Planning Application Ref: BE/180/16/PL

Location: Land adj. to 2 North Bersted Street, Bognor Regis

Description of works: Construction of 1 No two storey dwelling on a narrow storage yard

Project title			
North Bersted Street Bognor, West Sussex			
Drawing title			
Tree Constraints Plan			
Scale	Drawn	Date	
1:100@A1	GS	05.10.16	
Approved		JJ	
Drawing No	Revision		
LLD1051 / 01	00		
CAD Filename			
LLD1051/01/CAD

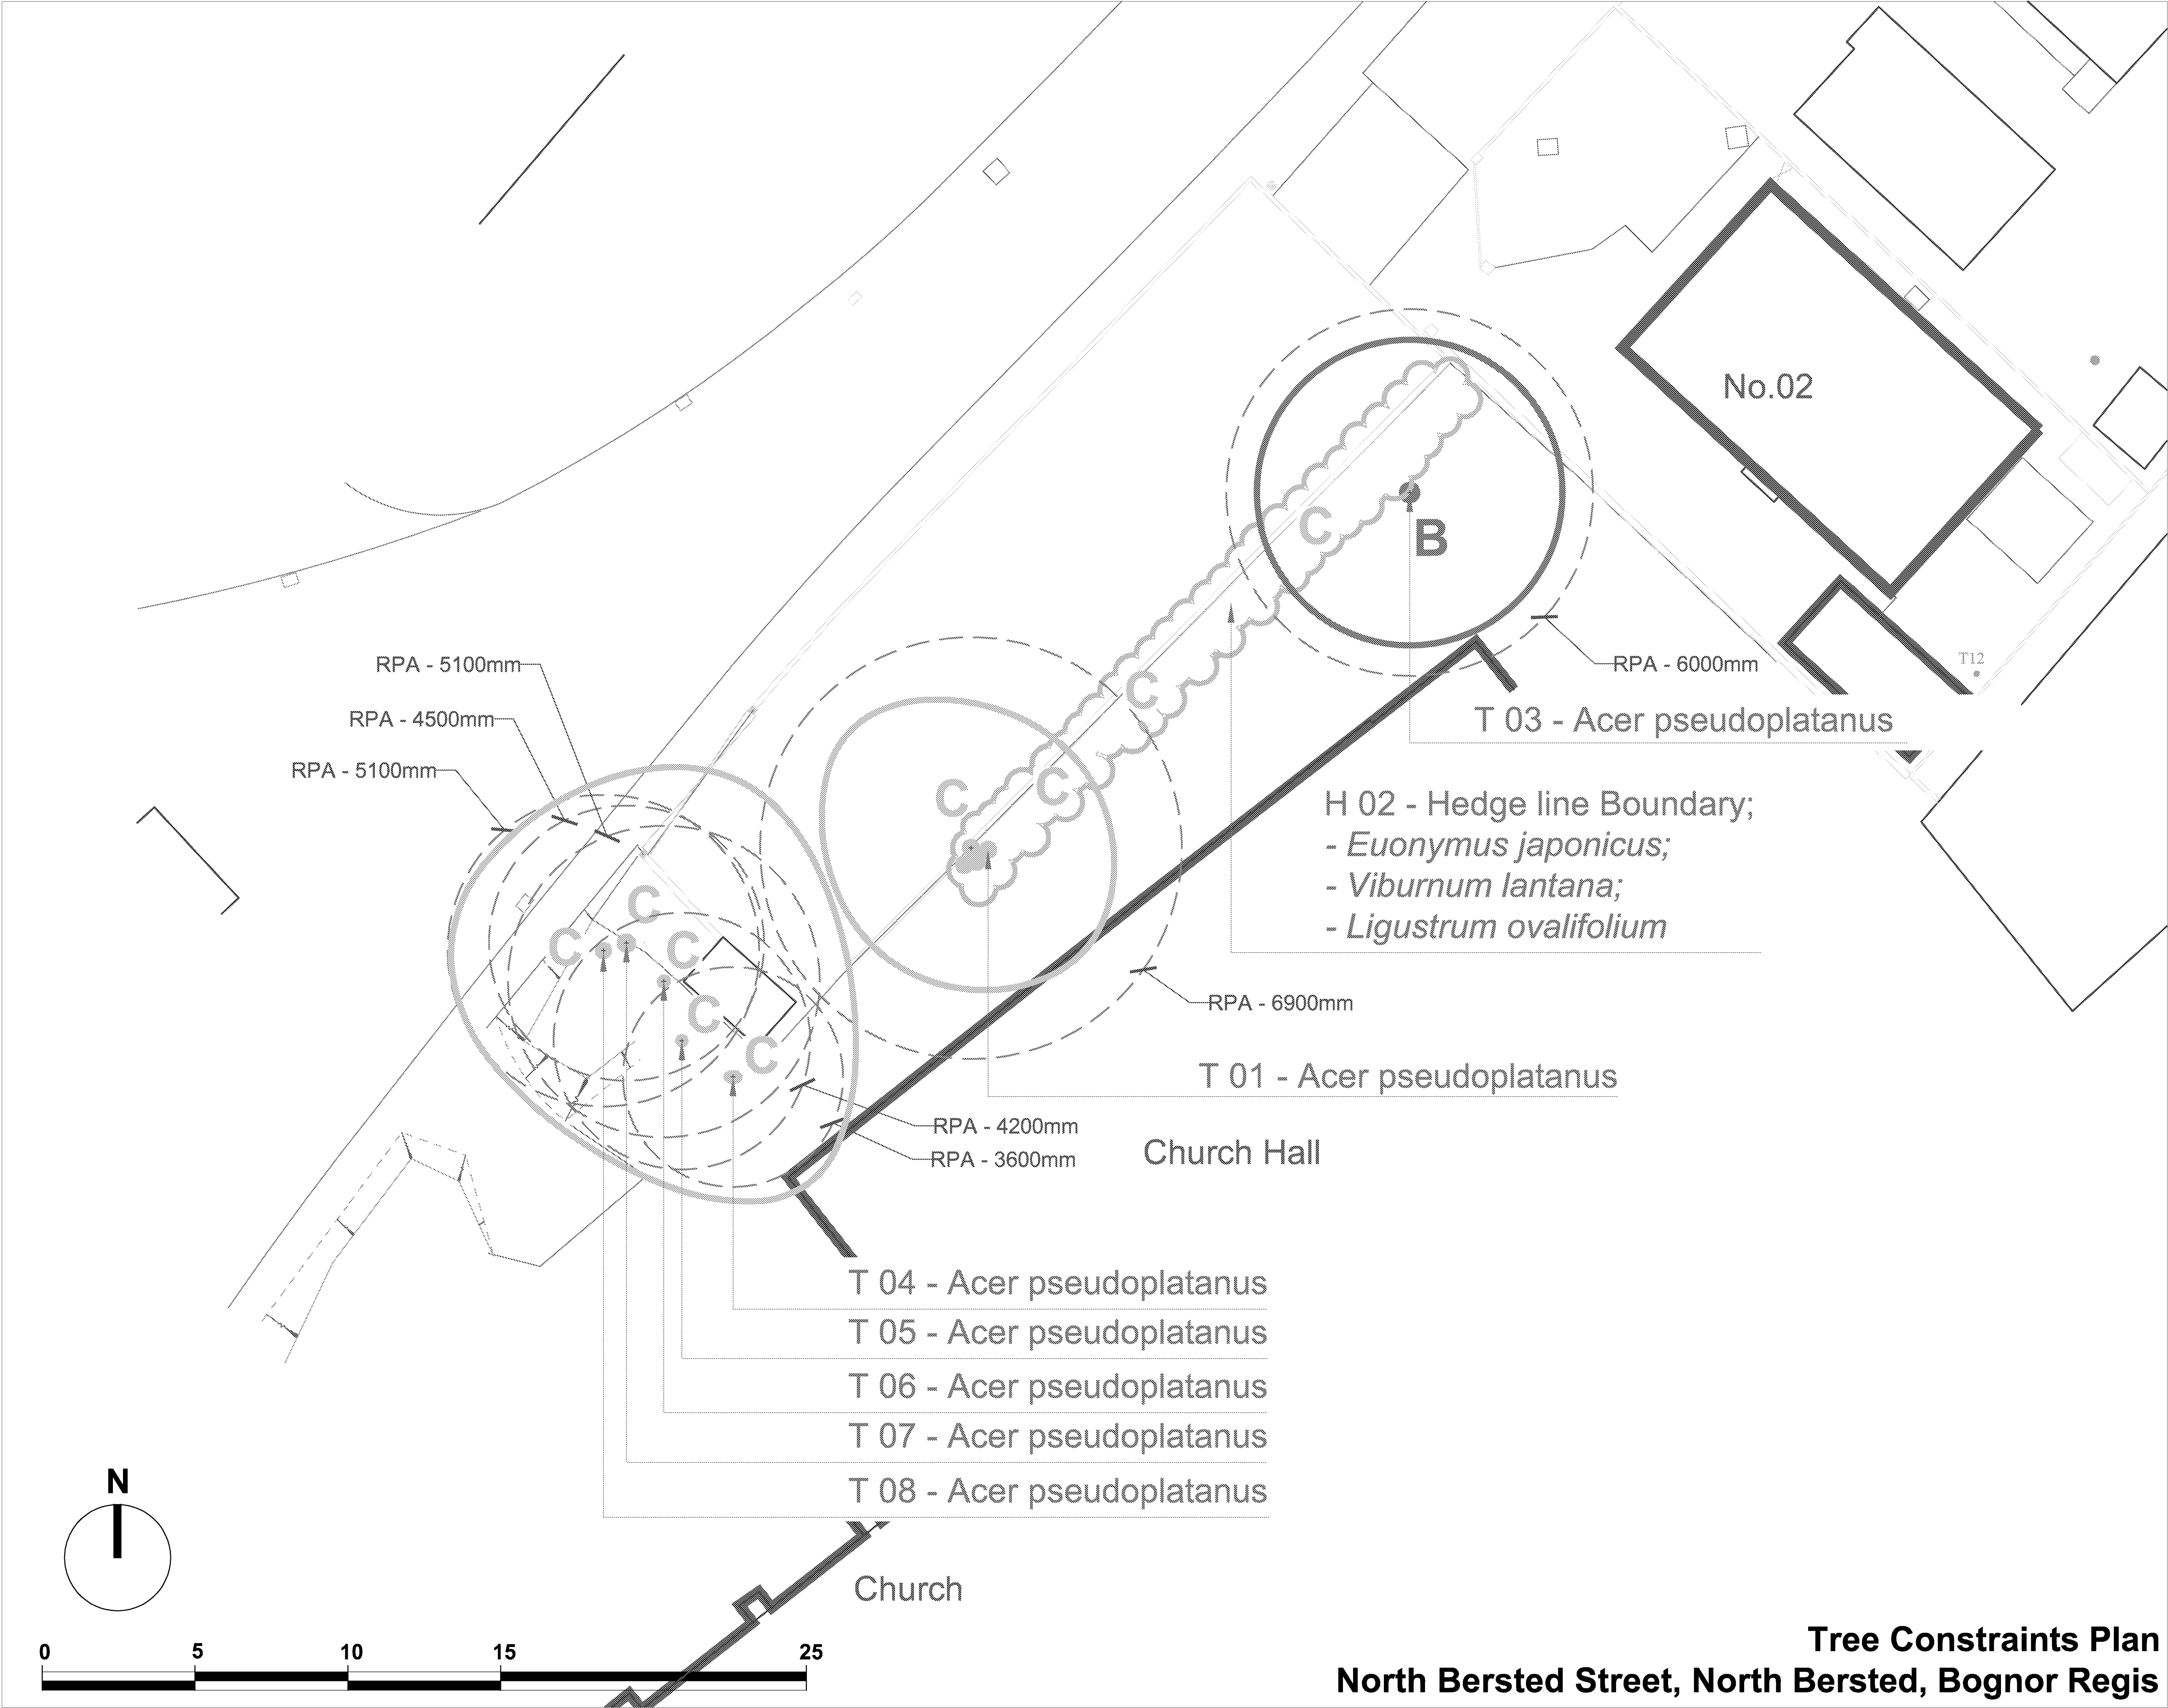
- The applicants have employed the service of **Lizard Landscape Design** who have prepared a Tree Survey & Root Constraints report with a Tree Constraints Plan but at this juncture no Arboricultural Method Statement Report complete with Tree Protection Plan has been submitted – all of which is required by BS5837:2012 in support of an application where trees are within influencing distance of proposals.
- There are no trees on this site but it is dominated and overshadowed by 8 self-sown off-site Sycamores that are young trees with significant potential for growth and expansion in the future.
- These are not trees of quality in the landscape but the fact remains that they exist and are not under the direct control of the applicants therefore they pose a constraint to the development proposed.

- The tree survey and constraints data is satisfactory.
- Squeezing a two storey development onto this narrow plot will have a detrimental impact on the off-site trees as they will be due south of the dwelling and within 1m to 2m of same therefore there will be 'pressure to prune or fell' them which does not constitute good design under the recommendations of BS5837:2012.
- I do not doubt that the new dwelling can be constructed without too much damage to the root systems but they will need to provide a detailed Method Statement & Tree Protection Plan report to justify this.

- I find that the base tree constraints data submitted in support of this planning application is fine as far as it goes but given the complexities of the build process there will be a need for them to supply further information in support of the application in the form of a detailed Method Statement & Tree Protection Plan report.
- As things stand I would have to register an **OBJECTION** to this scheme on the grounds of 'pressure to prune or fell the off-site trees.
